City of Portland, Maine - Building or Use Permit Application
 389 Congress Street, 04101 Tel: (207) 874-8703, Fax: (207) 874-8716

Permit No: 05-1698	Issue Date:	CBL: 013 C010001
------------------------------	--------------------	----------------------------

Location of Construction: 7 OXFORD ST EXT	Owner Name: FLORENDO LEA & MARICHU E FL	Owner Address: 7 OXFORD ST	Phone:
Business Name:	Contractor Name: Glen Rodney	Contractor Address: 28 Summit Street Old Orchard	Phone 2073291300
Lessee/Buyer's Name	Phone:	Permit Type: Demolitions	Zone:

Past Use: Storage/Garage	Proposed Use: Demolition Only -Demolish building w/intent to rebuild on same footprint	Permit Fee: \$30.00	Cost of Work: \$1,000.00	CEO District: 1
Proposed Project Description: Demolition Only -Demolish building w/intent to rebuild on same footprint		FIRE DEPT: <input type="checkbox"/> Approved <input type="checkbox"/> Denied	INSPECTION: Use Group: Type	
		Signature:	Signature:	
PEDESTRIAN ACTIVITIES DISTRICT (P.A.D.)				
Action: <input type="checkbox"/> Approved <input type="checkbox"/> Approved w/Condition <input type="checkbox"/> Denied				
		Signature:	Date:

56 Plot Plan

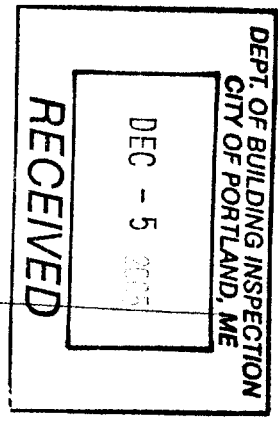
Note: 11/23/05 Left message with Glen Rodney. Need site plan to scale that shows porperty lines, principal structure and storage garage that is to be taken down. **Ok to Issue:**

12/01/05 Called Glen Rodney. Asked about site plan. He said that he had met with Arthur at the site. I spoke with Arthur and Arthur measured the shed and located it in relation to the fences. We still do not have a site plan and Arthur does not think that Glen is capable of making one. I left a message with the owners that we need a site plan.

11/23/2005-amachado: Left message with Glen Rodney. Need site plan to scale that shows property lines, principal building and storage garage that is to be demolished.

12/01/2005-amachado: Left message with the Florendos (owner). We still need a site plan locating house and storage shed on lot.

12/05/2005-jmb: Met w/Glen R., he submitted plot plan, also reviewed future plans for new structure. They may want to change the use of the property and will need more details before that permit can be issued.
